Harnett County Government Complex  
307 Cornelius Harnett Boulevard  
Lillington, NC 27546

January 19, 2006

**Re: Status of Improvement Permit Application #05-5-13426  
Lot 186 Crestview**

LOT # 186 CRESTVIEW

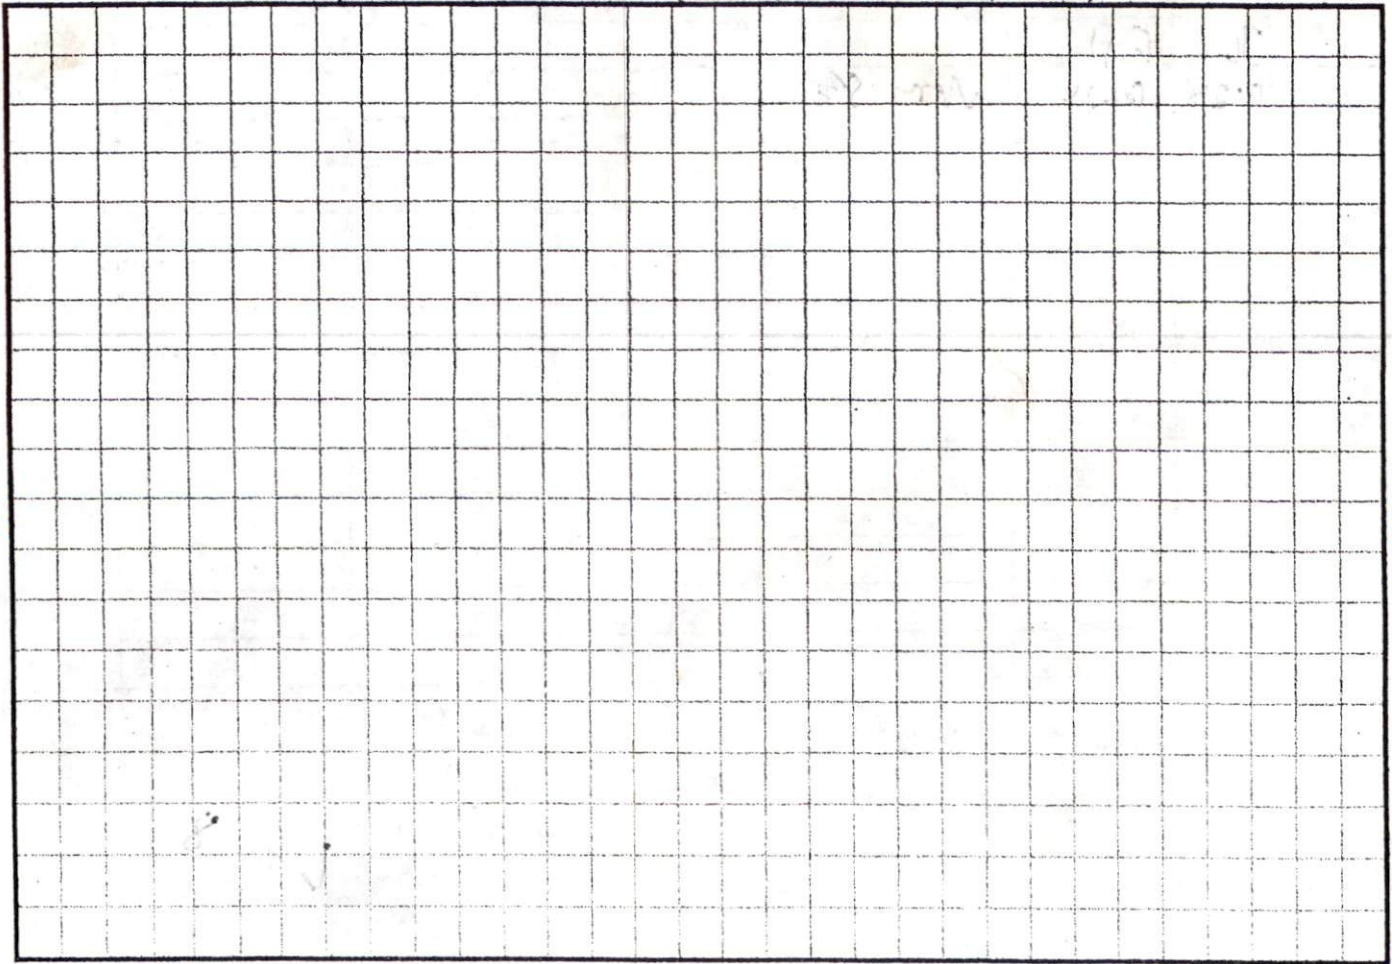
- \_\_\_\_\_ 1. Property lines/corners not marked or labeled
- \_\_\_\_\_ 2. House corners not marked or labeled
- \_\_\_\_\_ 3. Directions not clear to property
- \_\_\_\_\_ 4. Property needs brush or vegetation removed
- \_\_\_\_\_ 5. Backhoe pits required
- X   6. Other Move house to required set backs as shown. Note – garage must be side entry. Drive must be along property lines – note house size may have to decrease in order to fit on lot
